548 St. John Street Permit# 2017-00173

I am currently reviewing your project for verification of compliance with the State and local Life Safety Codes, and need the following information to complete my review:

A1.10

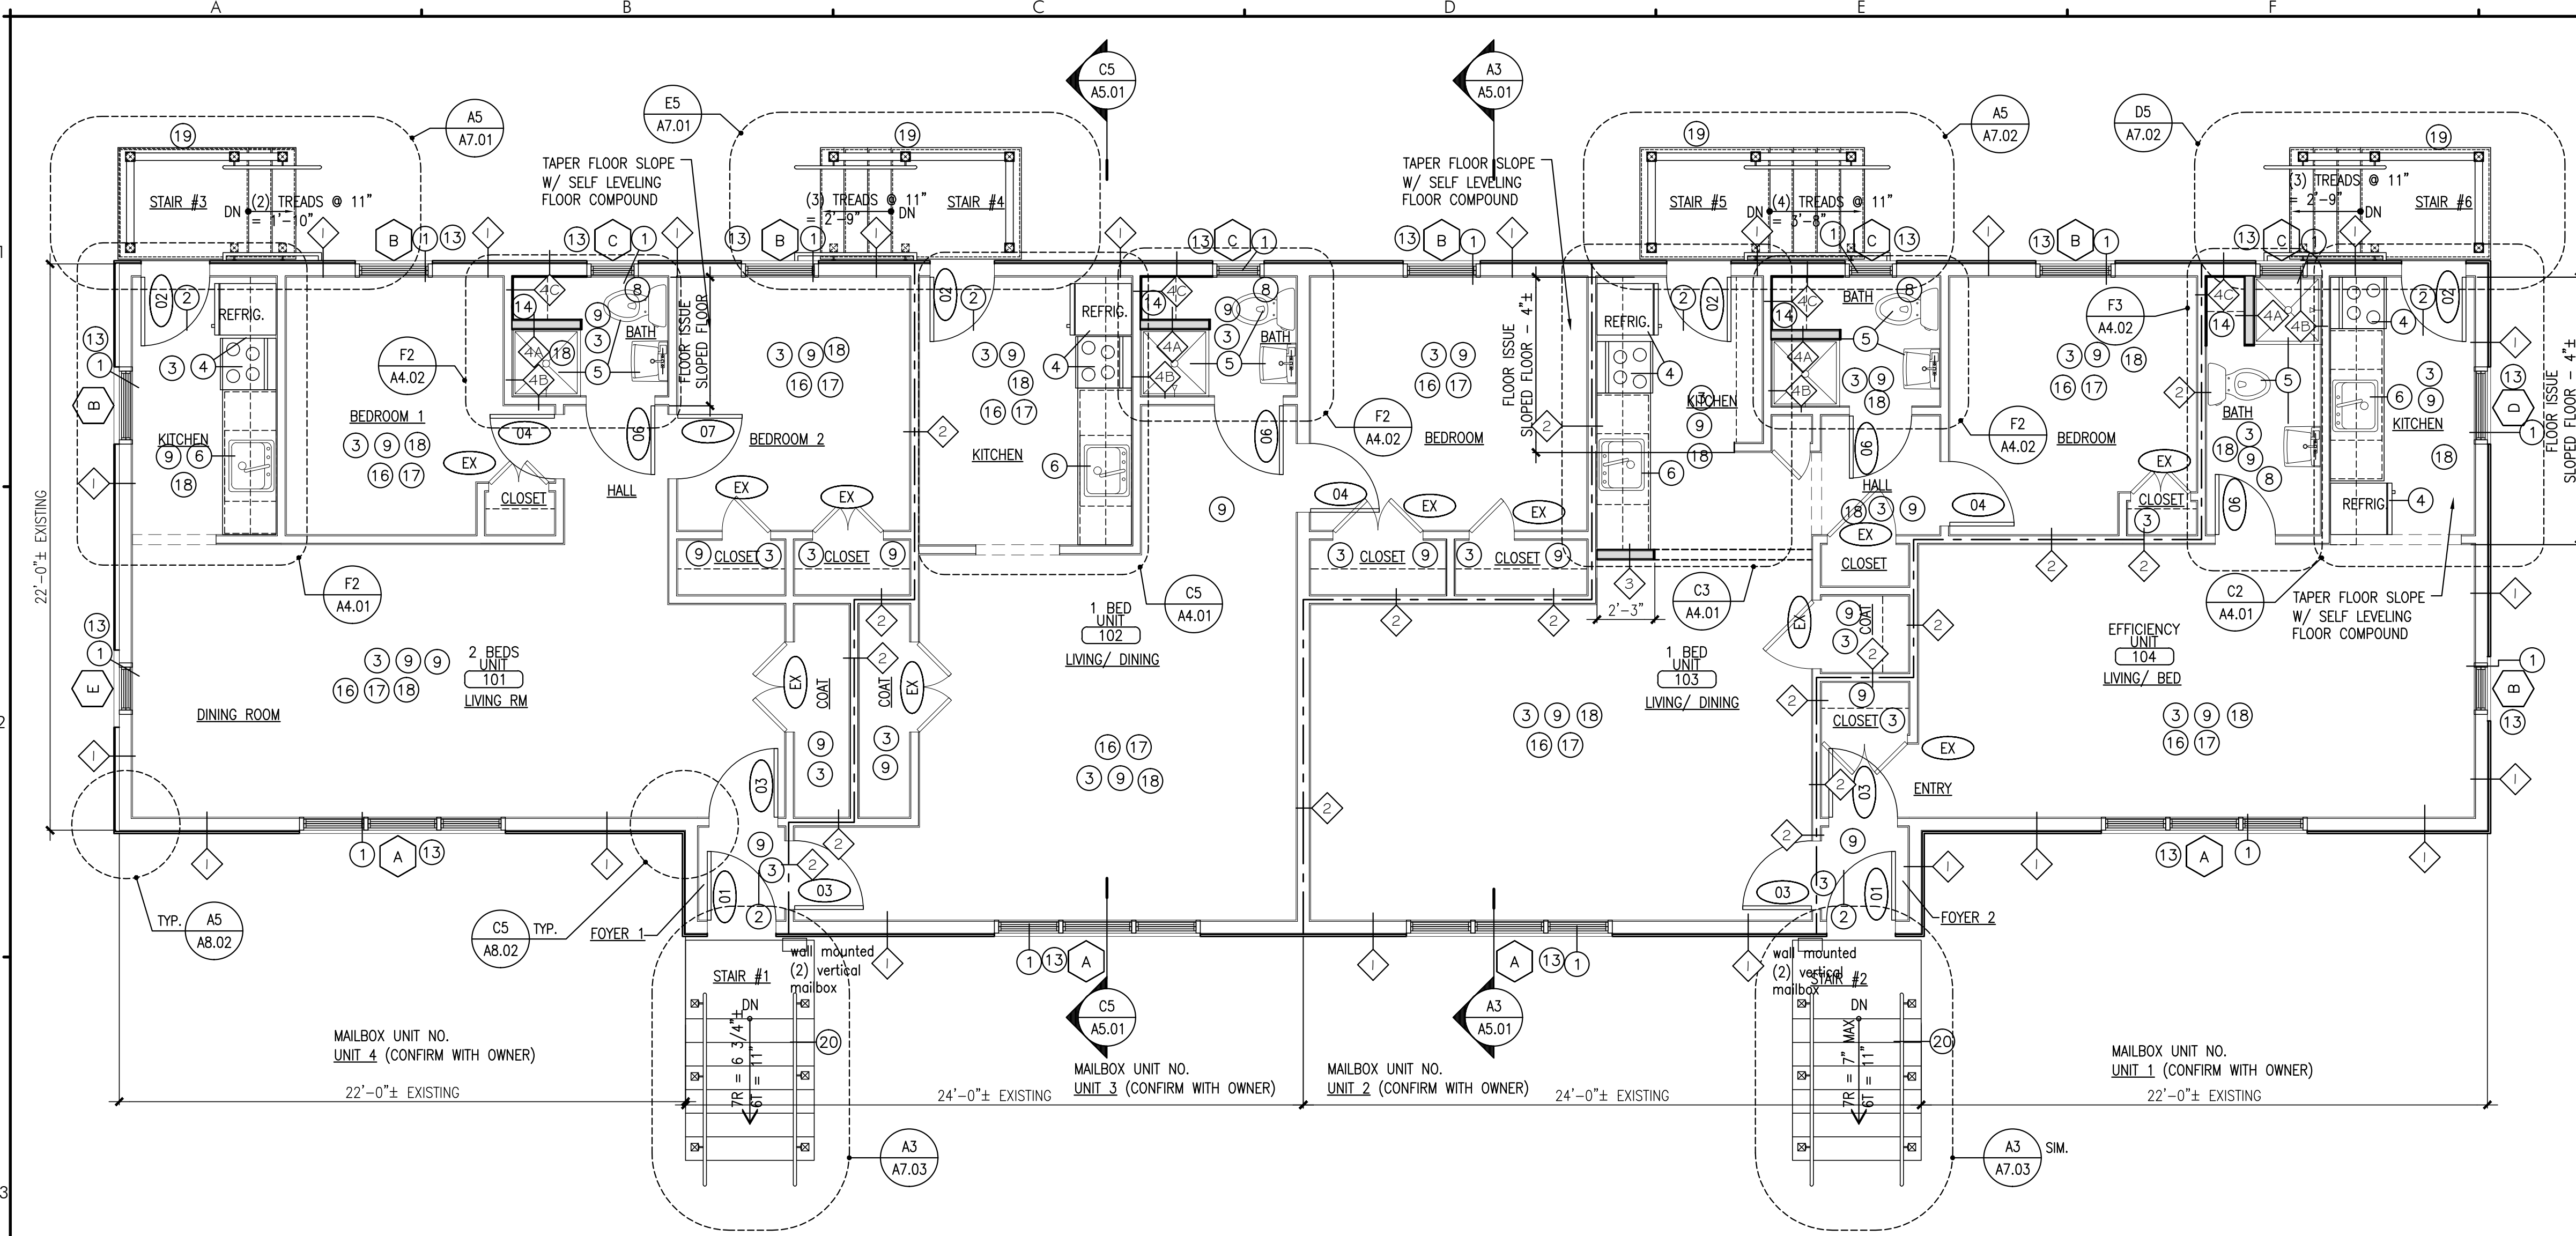
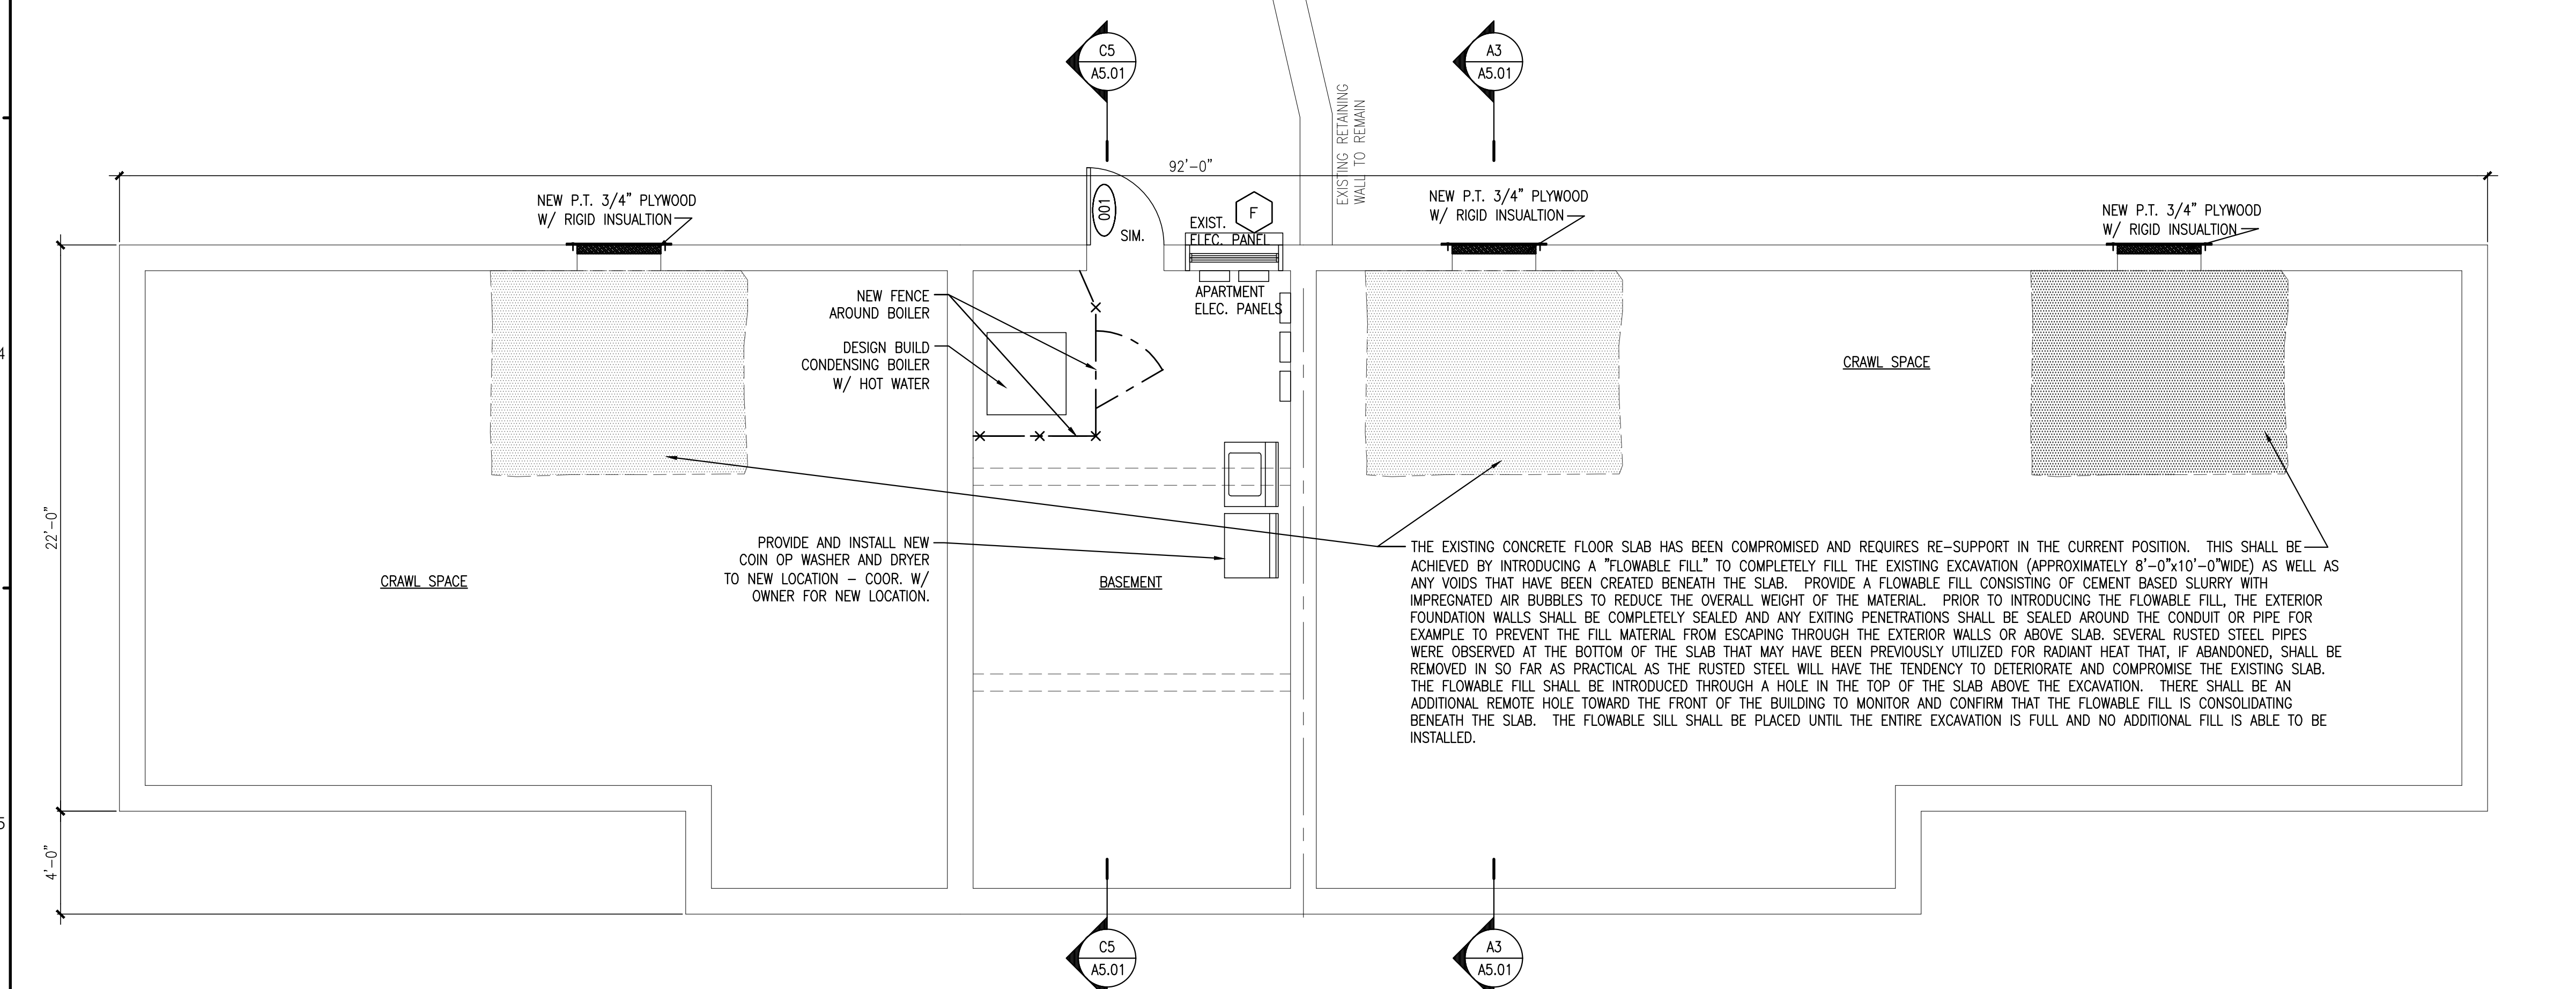
1. Please indicate on a plan that the windows in the bedrooms meet the attached requirements for egress windows in a building built before 1976. The studio apartment does not need an egress window since the sleeping area has 2 accessible door from it. **Were there some attached requirements referenced? The proposed windows are NOT egress sized, however 702.5 of the IEBC exempts replacement windows from being enlarged to egress size in Level one Alterations (where one replaces in-kind without configurations changes). For the sake of history, our first set of plans showed these bedroom windows being enlarged to egress size but these were deleted during VE to save money per the provision above. CWS still feels it would be a good life safety benefit to replace these windows with egress windows if the resources are available.**

2. The basement boiler / laundry room need to be protected from the apartments by either a fire separation or fire sprinklers. please indicate which protection feature you will be using on a plan. **Per the code review: IBC 2009 - Table 508.2.5: There are laundry room incidental use areas within the scope of the project. 1 hour provided. The existing boiler room has concrete walls on all wall and a concrete ceiling.**
